EAST PARK ENERGY

**Applicant's Response to Deadline 3
Submissions – Host Authorities, Statutory
Environmental Bodies and Statutory
Undertakers**

Document Reference: EN010141/DR/8.39

July 2026
Version P01

Figure 54: Trench 935 Excavated Features

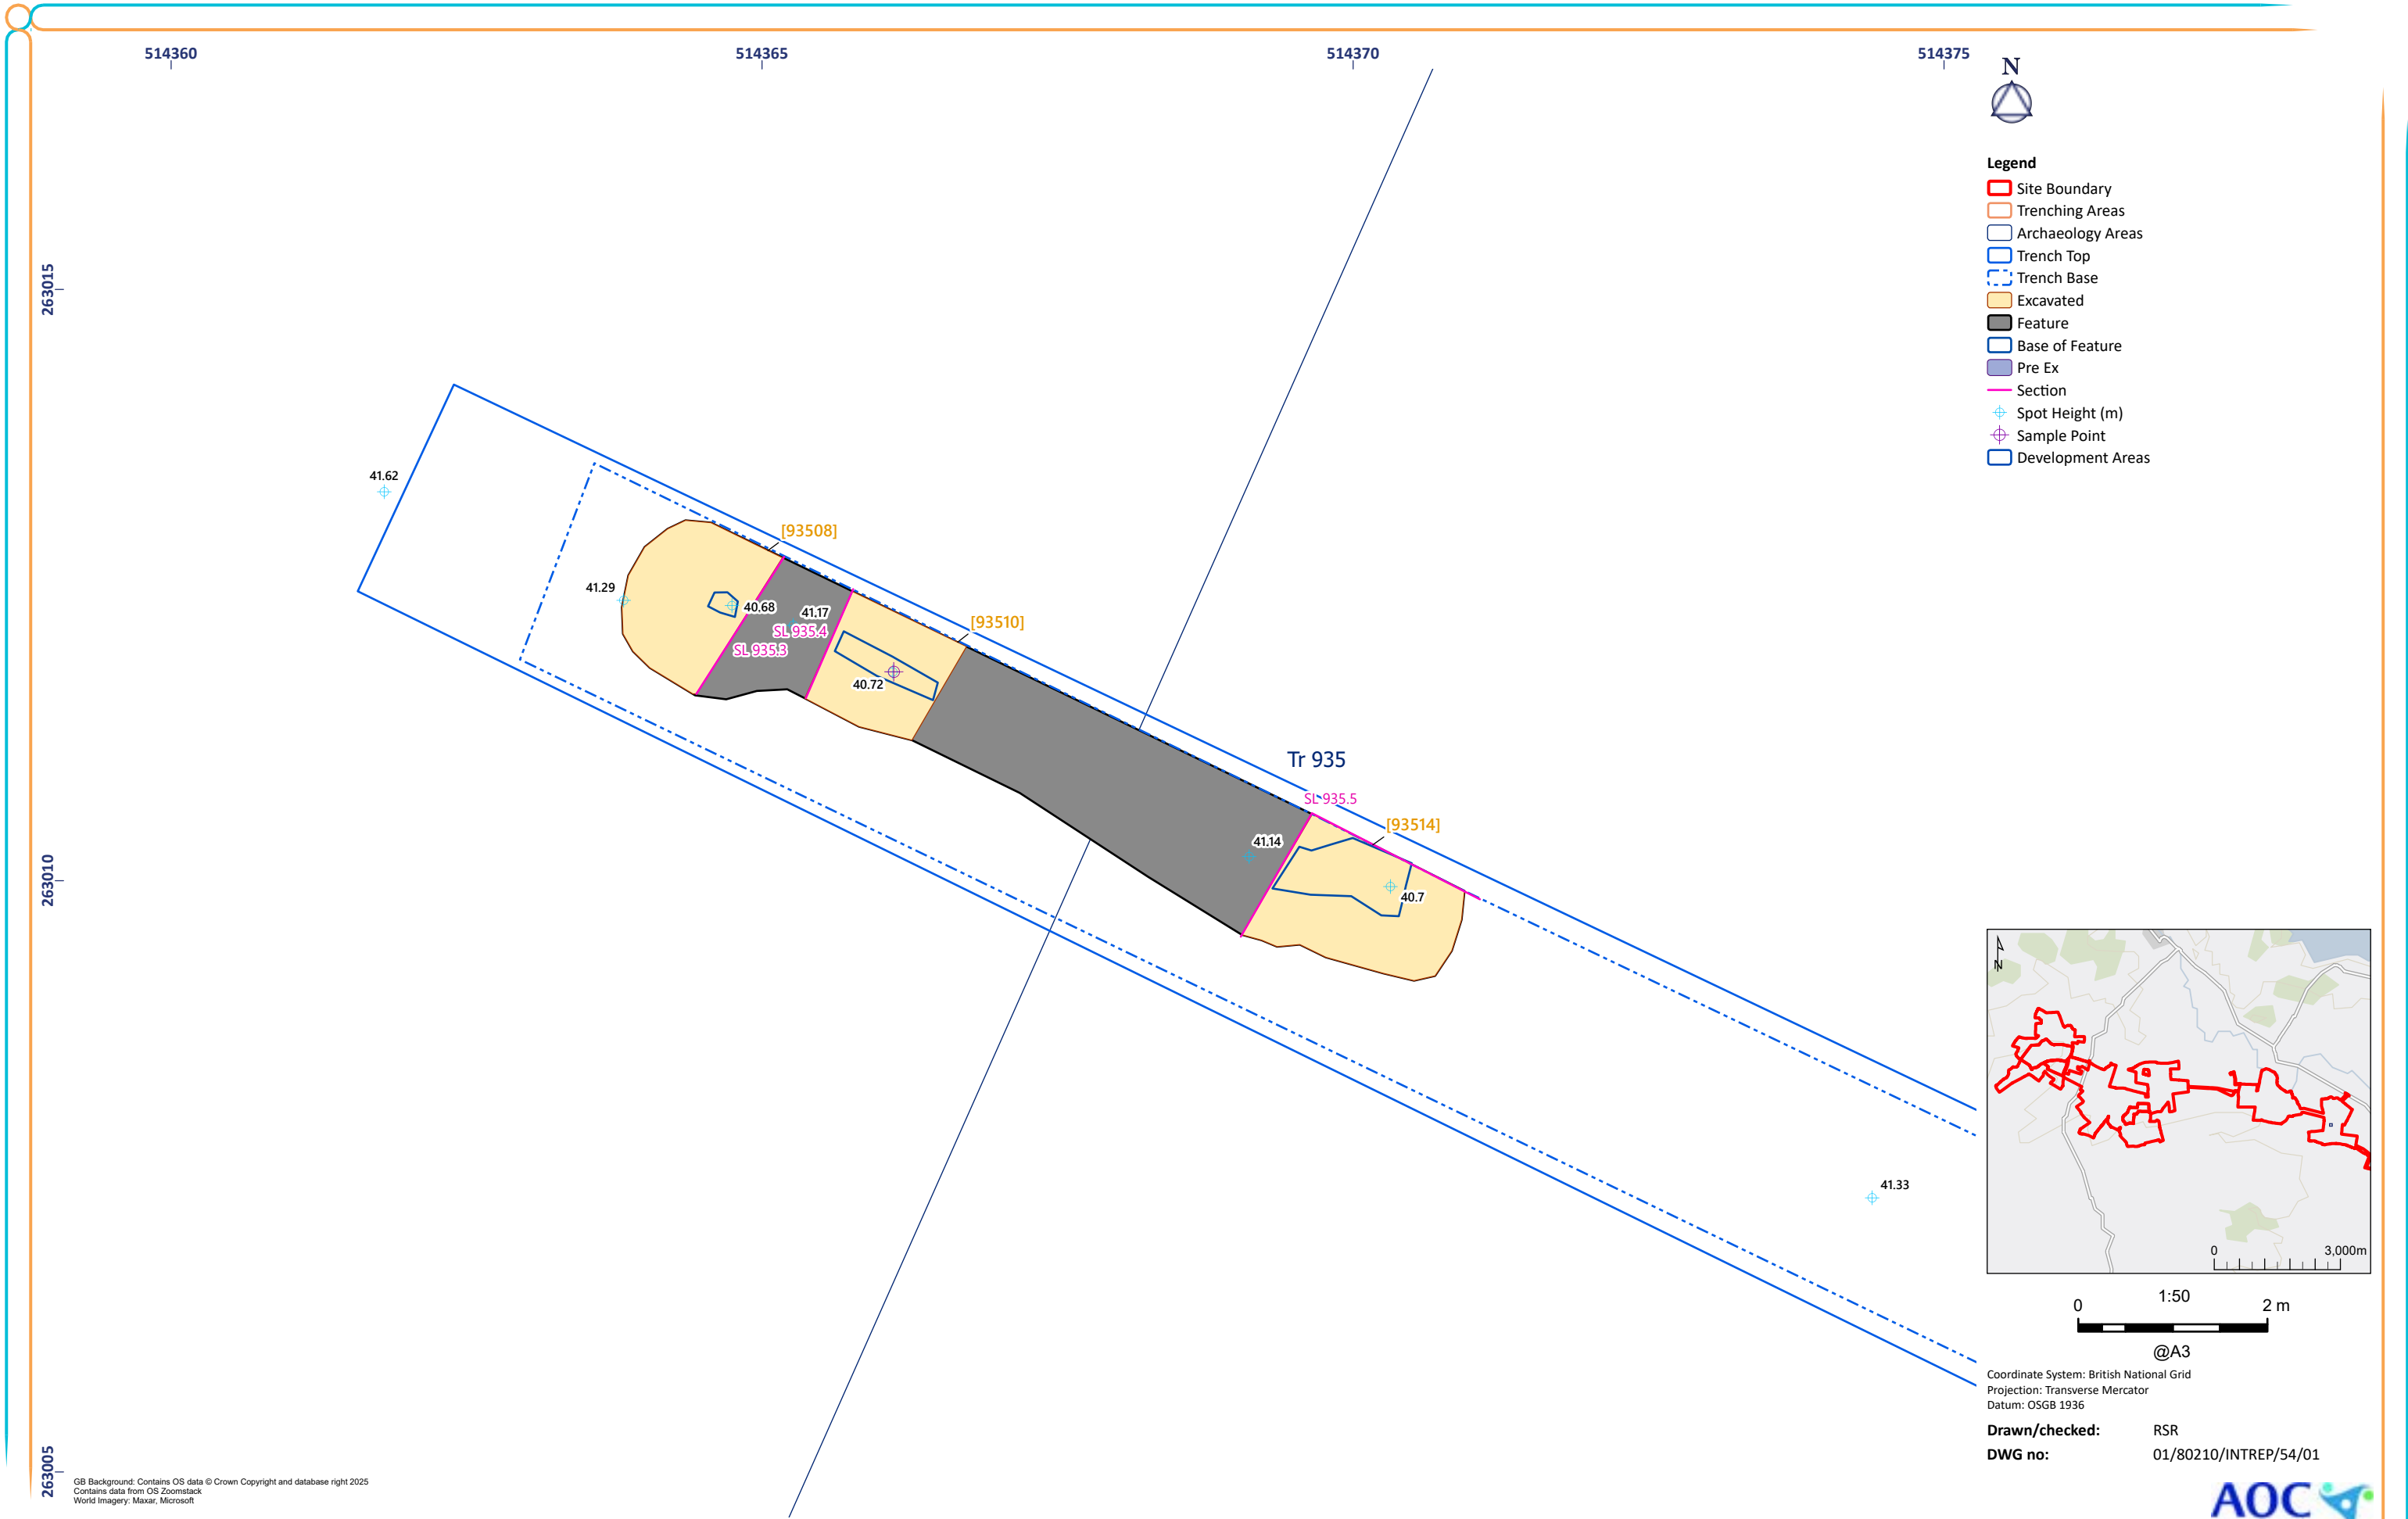
Our Ref.	Ref.	CCC Comments	Applicant Response
CCC-D3-11	3.1	The wording should be changed to Area D, not Area B.	ES Vol 2 Appendix 6-9: Site D Trial Trench Evaluation Final Report [as updated alongside this submission] has been amended for Deadline 4.
CCC-D3-12	6.64	The results for Trench 935 need further consideration of why the geophysical anomalies did not show up, especially as a feature was found in section.	ES Vol 2 Appendix 6-9: Site D Trial Trench Evaluation Final Report [as updated alongside this submission] has been amended for Deadline 4.
CCC-D3-13	11.1	This did not take place – the Council would like to request for this to be removed.	Section 11.1 of ES Vol 2 Appendix 6-9: Site D Trial Trench Evaluation Final Report [as updated alongside this submission] has been amended for Deadline 4.
CCC-D3-14	Figures	None of the detailed trench plans contain feature or cut numbers – please can the applicant review and amend this document as features can only be located on a detailed read of trench descriptions.	The Applicant notes that the detailed trench plans (Figure 4.1 onwards) within ES Vol 2 Appendix 6-9: Site D Trial Trench Evaluation Final Report [REP2-018] are illustrated with cut numbers.
